**Part Of OS Parcel 5720 East Of Kyleburn And  
West Of Manor Farm Main Street Wendlebury**

**23/03282/DISC**

**Proposal:** Discharge of Conditions 3 (means of access), 4 (field shelter details), 5 (waste bins and bin stores details) and 6 (Biodiversity Method Statement) of 23/02380/F

LOCATION and BLOCK PLANS As Existing & As Proposed
1:2500, 1:500, 1:50 TPH August 2023
Original at A1 Drwg no. 23 / 201.02 Rev A

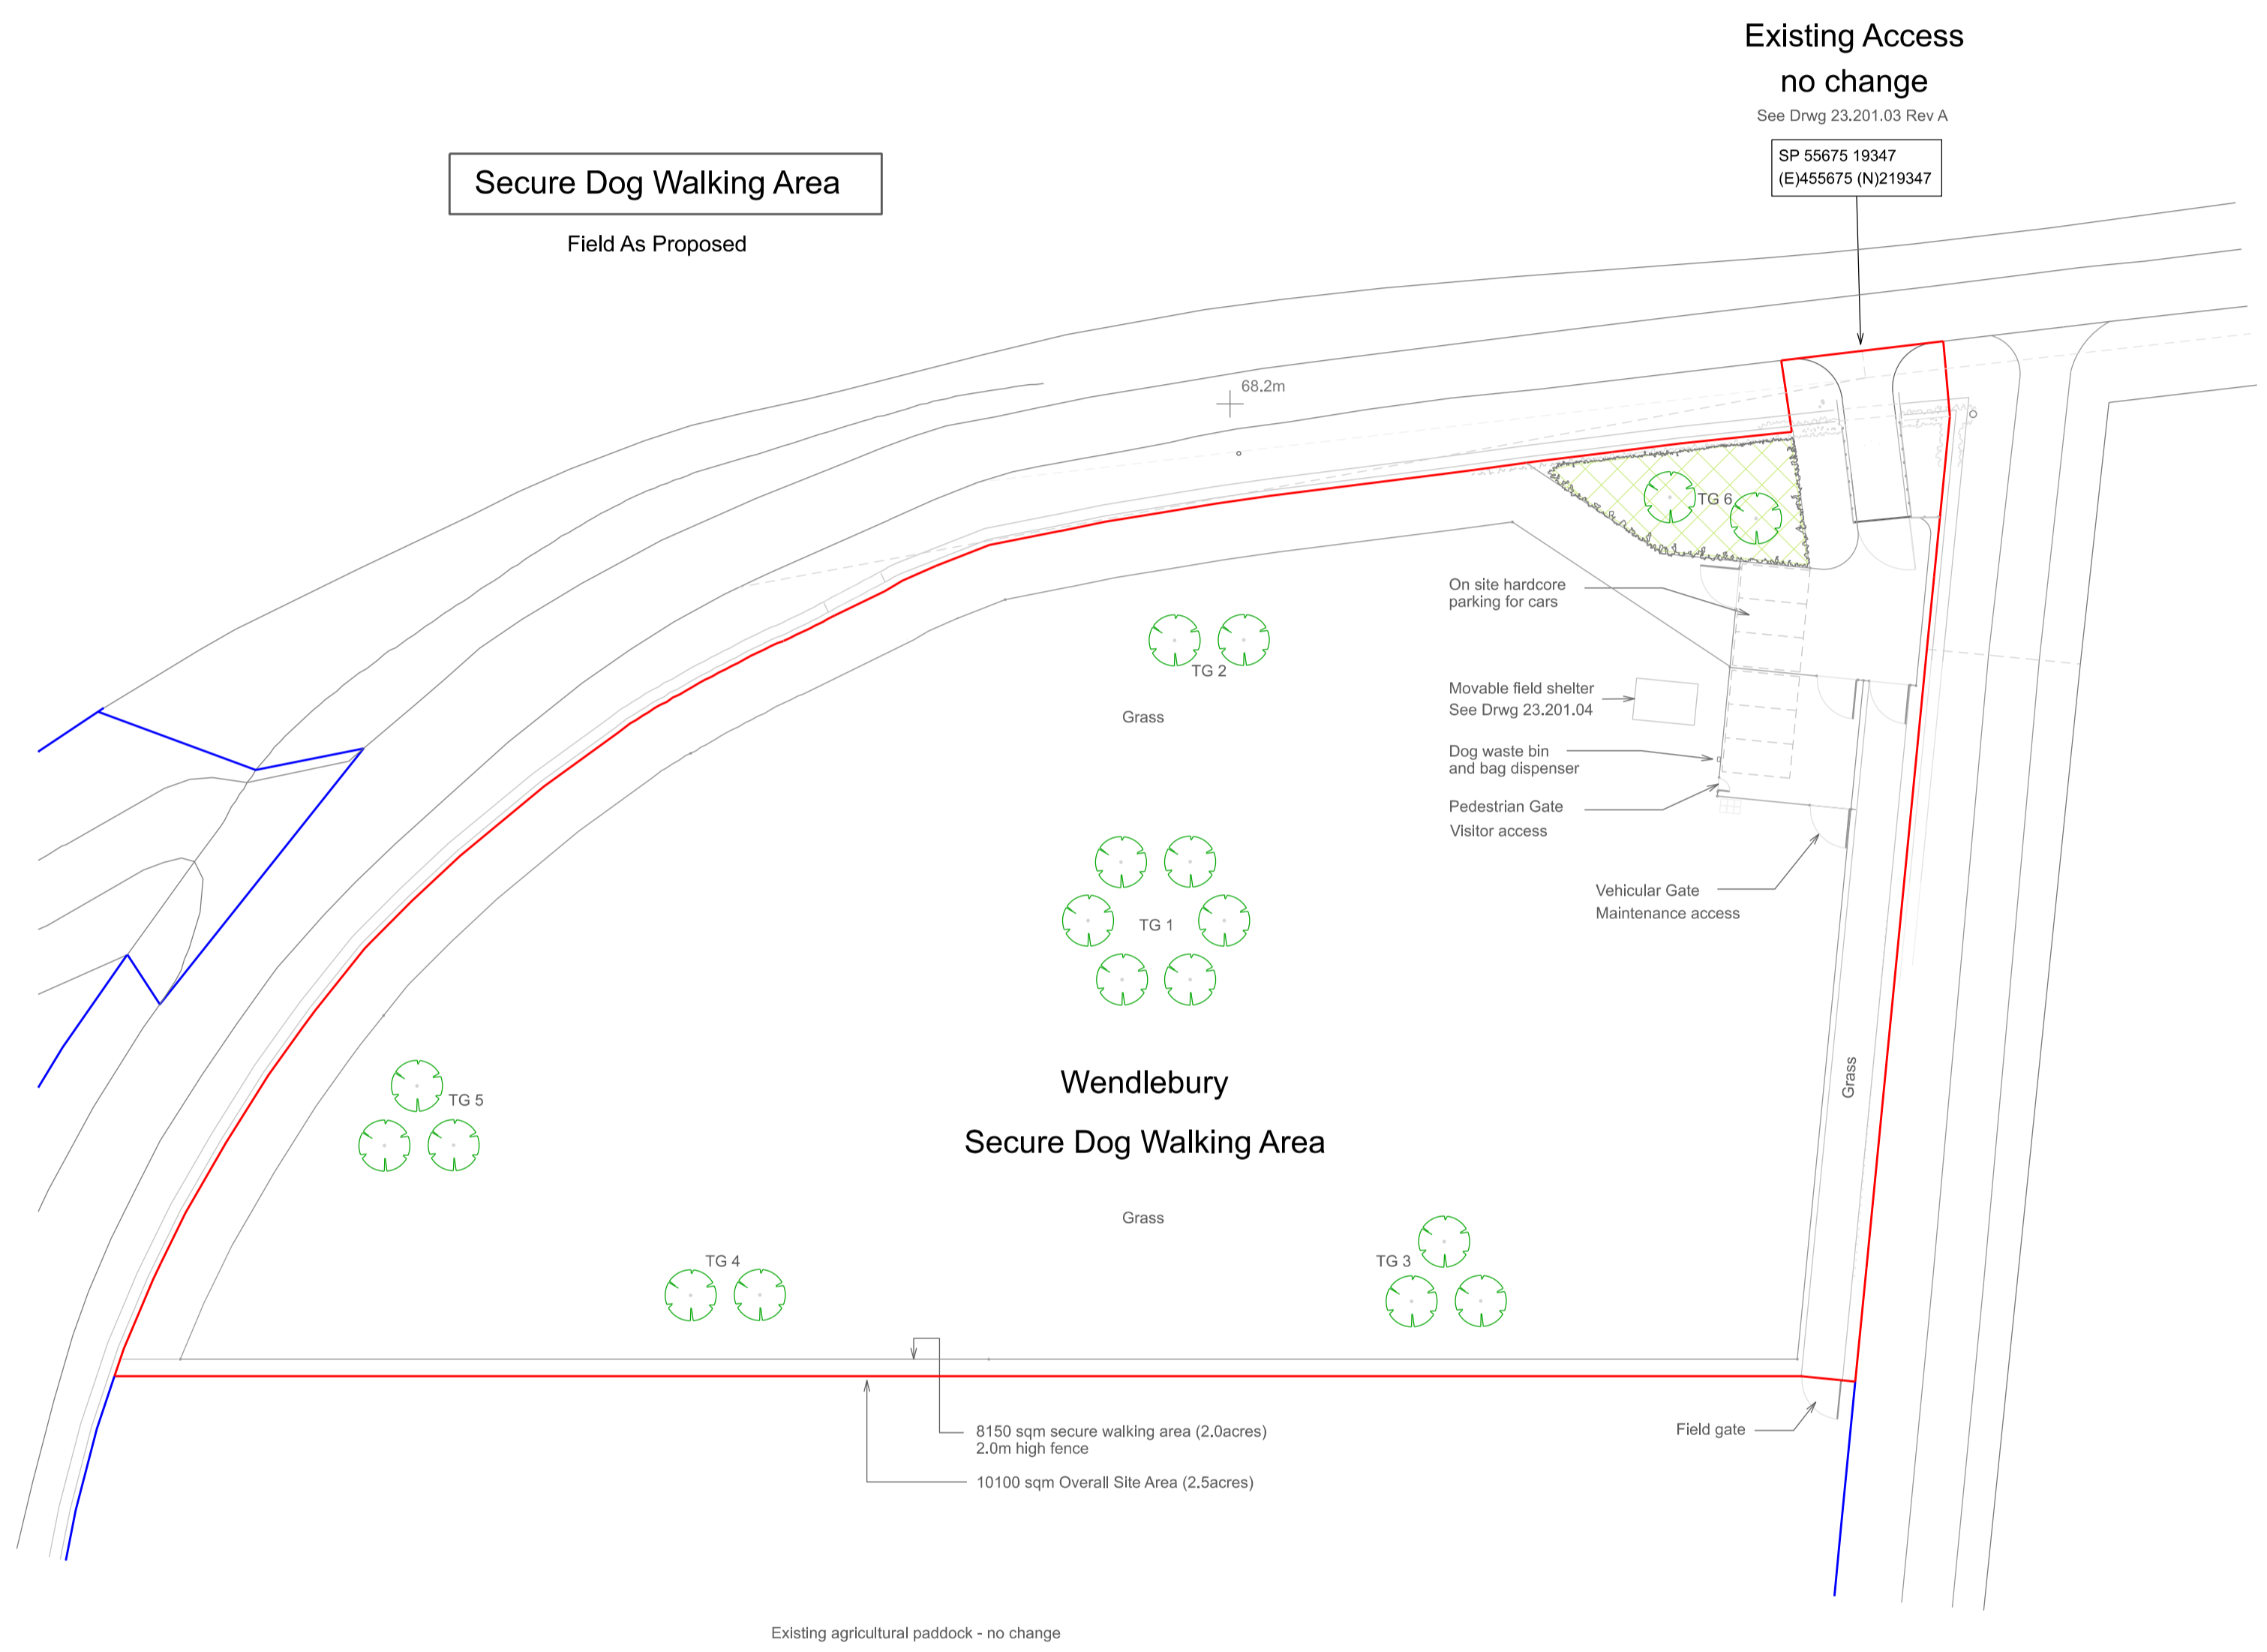
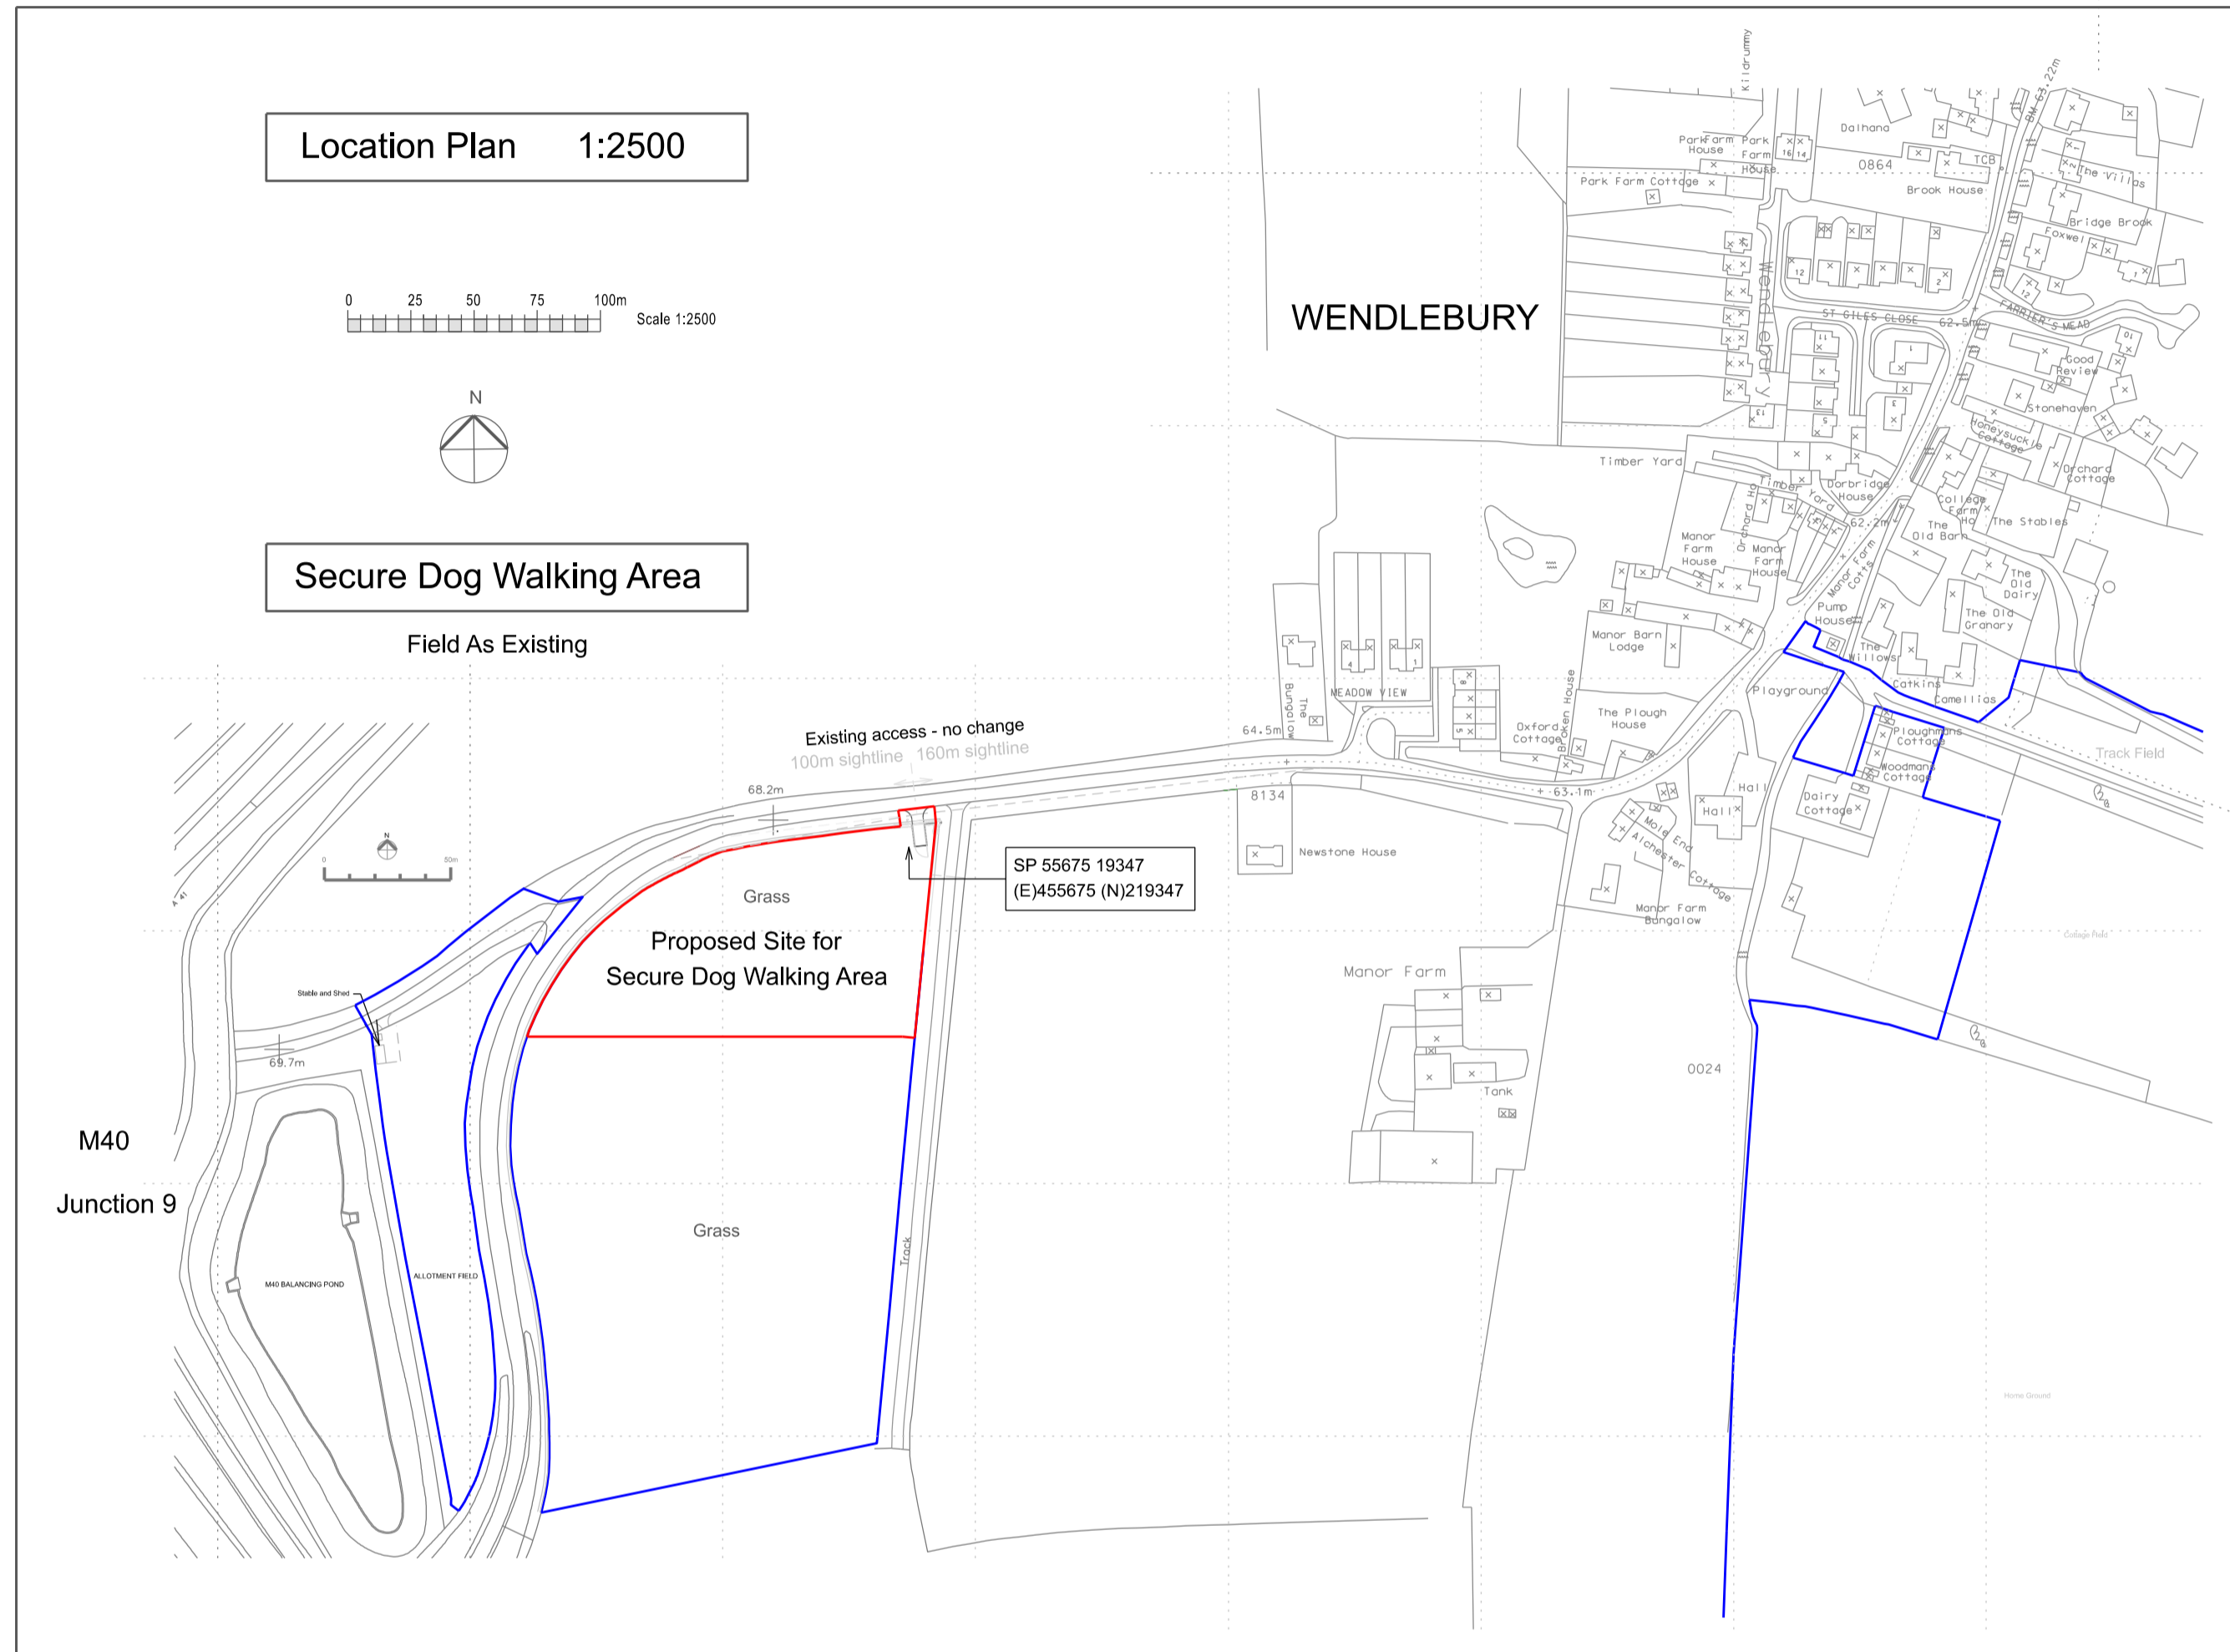
- 2.3. Condition 5 – sought details of waste bins and bin stores. This was submitted in the form of an Addendum to the Design and Access Statement dated 23 November 2023 and Drawing No. 23.201.02 Rev. A.

6.3. Condition 5 – Suitably designed waste bins would be provided on site and regularly collected. The Environmental Health Team have raised no objection to the submitted details and I consider these to be acceptable.

6.4. Conditions 6 – Whilst the Ecology Officer has not provided any comments on the scheme, 2 bird nest boxes would be installed and 18 new trees would be planted, which would, in my opinion, constitute an enhancement for biodiversity within the site. I therefore consider the details to be acceptable.

Condition 5 – Waste bins and bin stores in accordance with Addendum to the Design and Access Statement dated 23 November 2023 and Drawing No. 23.201.02 Rev. A.

Condition 6 – Method statement for enhancing biodiversity in accordance with Addendum to the Design and Access Statement dated 23 November 2023 and Drawing No's. 23.201.02 Rev. A and 23.201.04.
